**Subject:** Eagle Rising SF2225 Plat Filing 1 Response Letter and EDARP Upload

Our responses to the EPC June 6, 2024 Plat and related documents review comments and the Applicant Team/EPC June 24<sup>th</sup> and July 11<sup>th</sup> review meetings have uploaded EDARP.

DRAINAGE EASEMENT DETAILS
 LOTS 3 & 6
 SCALE: 1" = 50'

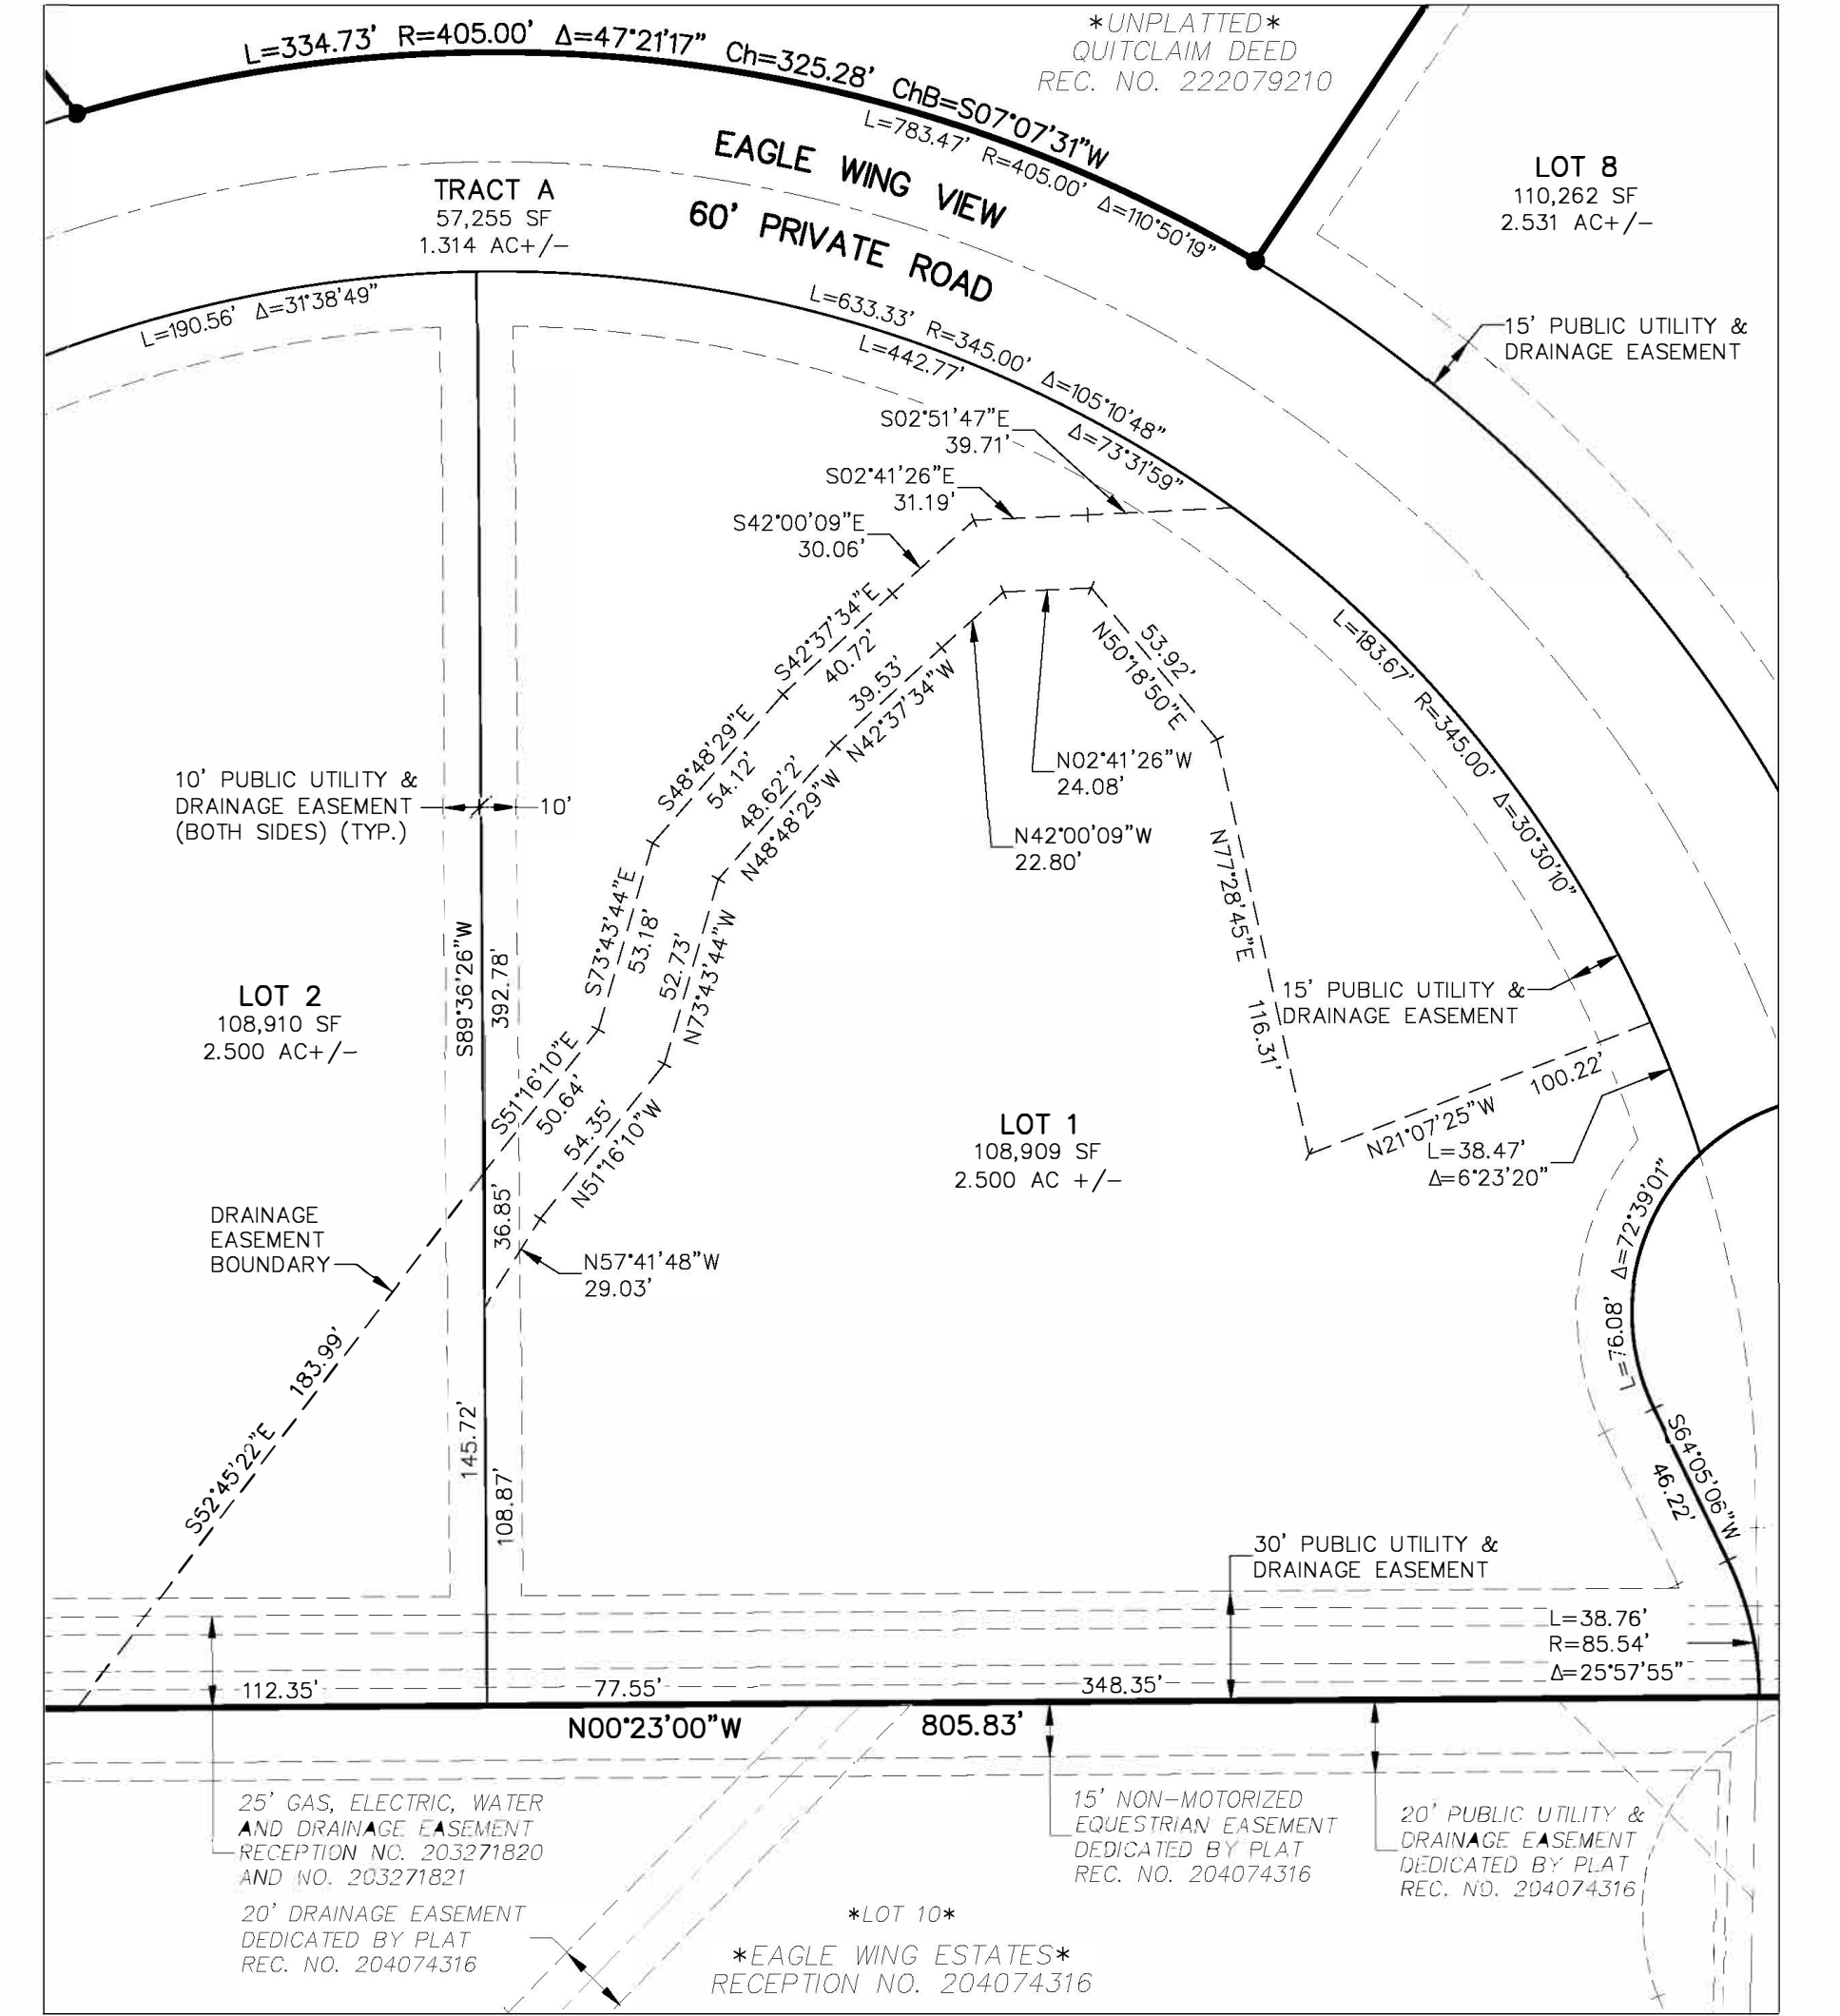
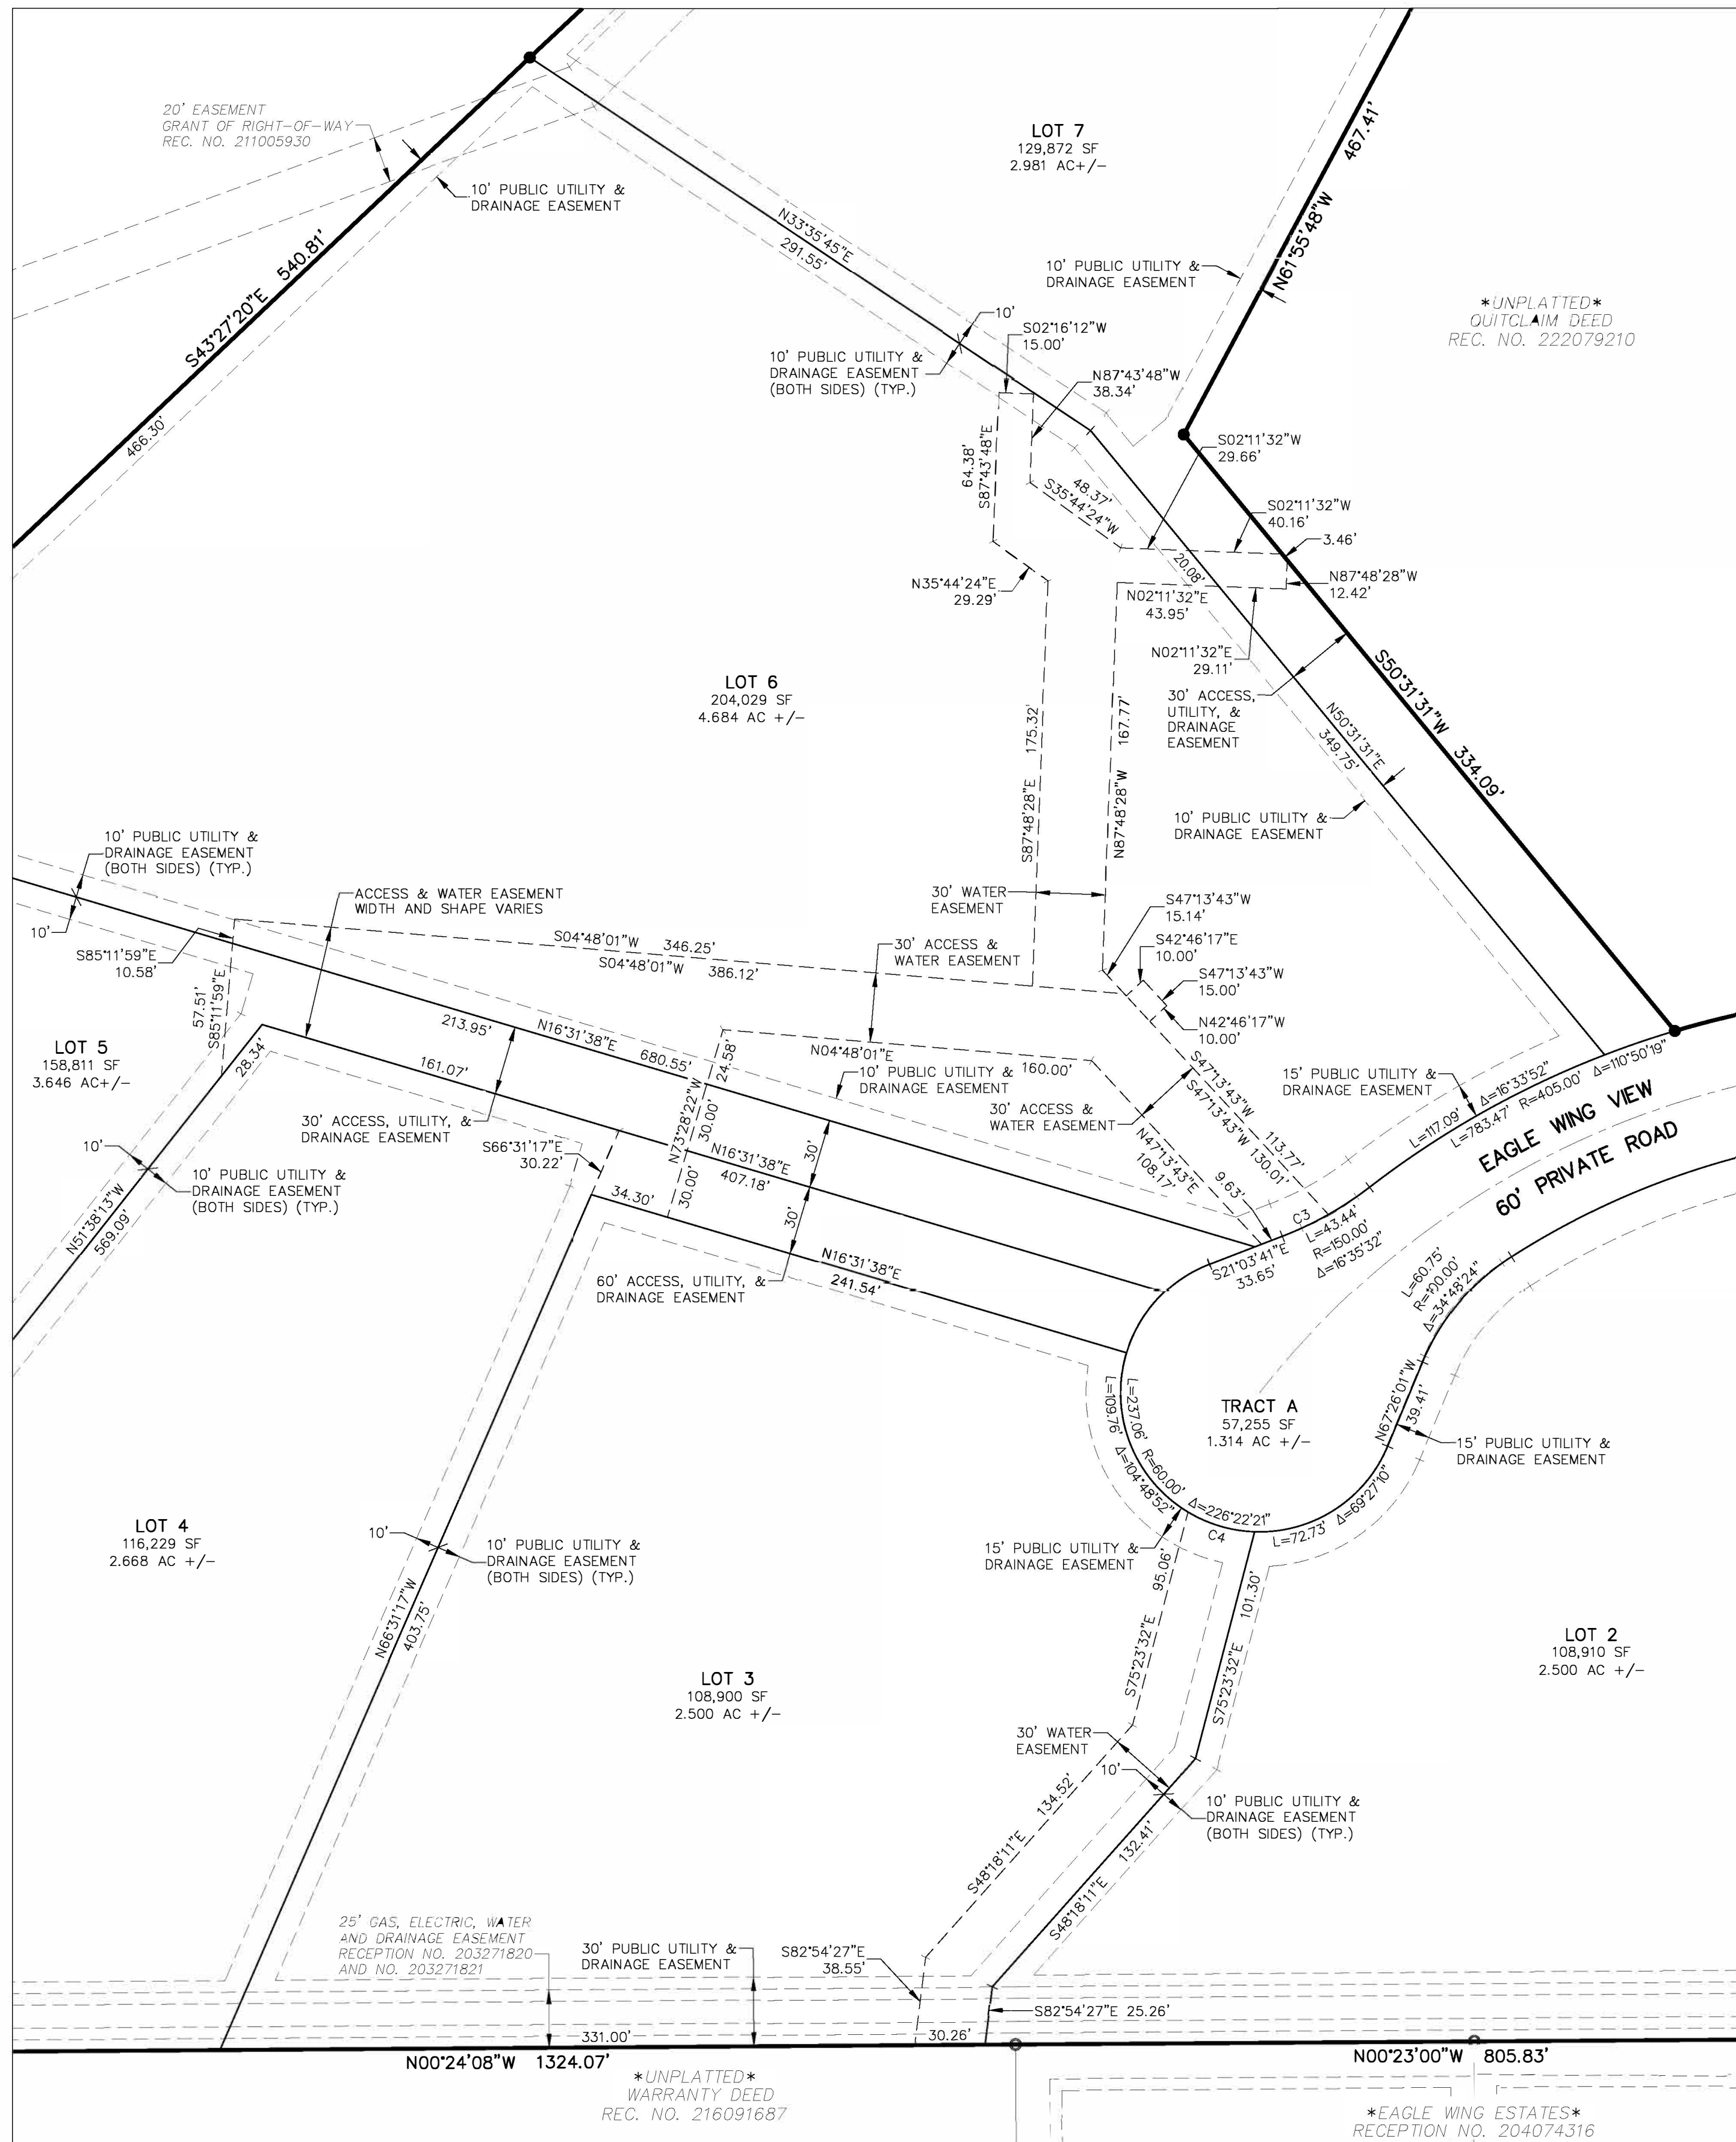
53	Eagle Rising Filing No 1 Final Drainage Report	PCD Engineering Division	Yes	Jeff Rice	6/6/2024 10:41	(FDR redlines)	213	Unresolved: Show all drainage easements. If individual lots are required to obtain/provide easements with engineered site plans indicate that with note(s).	E - Answer provided	7/30/2024	Eagle Rising Filing No 1 Final Drainage Report	-	Drainage easements shown and labeled	
54	Eagle Rising Filing No 1 Final Drainage Report	PCD Engineering Division	Yes	Jeff Rice	6/6/2024 10:41	(FDR redlines)	213	Show culvert, add note on who's installing	E - Answer provided	7/30/2024	Eagle Rising Filing No 1 Final Drainage Report	-	Plan is to not fill pond - to remain as shown. Access for Lots 4,5, and 7 is to be via the access easement through Lot 6 as shown on the plat. No driveway culverts required. However, alternate access provisions with culverts has been added to the drainage report to be placed by future lot owner if future driveway construction. Engineering consultation advised. The pond outflow path has been updated.
